Net Zero Teesside Project

Planning Inspectorate Reference: EN010103

Document Reference: 9.31 – Response to Examining Authority's Written Question DLV 1.7 ii

Date: August 2022

Figure 17-8a

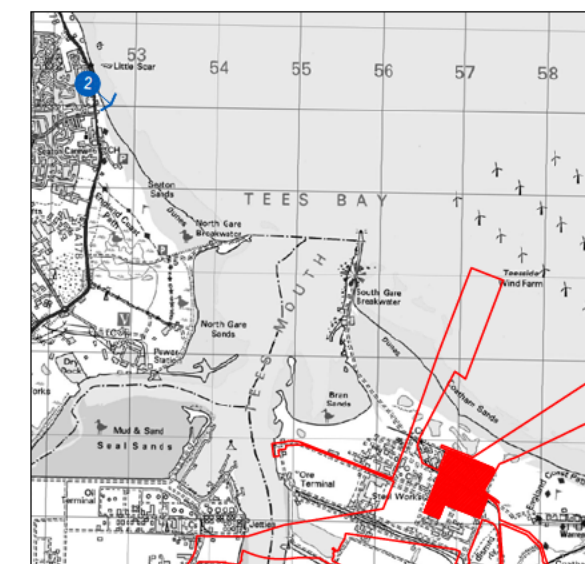
- 3.1.1 In Action Point 1 arising from Issue Specific Hearing 4 [EV8-006], the Examining Authority requested updated visualisations for Viewpoint 2 so that the viewpoint photography was taken from the sea front on the seaward side of The Cliff at Seaton Carew, rather than on the corner of The Green and The Cliff to provide a more representative viewpoint for receptors.

- 3.1.2 The Applicants have undertaken updated viewpoint photography and visualisations at an alternative viewpoint location, in close proximity to the original Viewpoint 2 photography within the ES Chapter 17 [APP-099]. The updated Viewpoint 2 visualisations listed below have been submitted at Deadline 6:

- Figure 17.8a: Viewpoint 2 The Cliff Seaton Carew (Summer) (Document Ref. 6.3.77)
 - Figure 17.20: Viewpoint 2 The Cliff Seaton Carew Massing (Document Ref. 6.3.110)

- Figure 17.21: Viewpoint 2 The Cliff Seaton Carew Photomontage (Document Ref. 6.3.111)
- 3.1.3 It is judged by the Applicants that the baseline and subsequent assessment within the ES Chapter 17 [APP-099] on recreational and residential receptors would not change as a result of the alternative viewpoint.
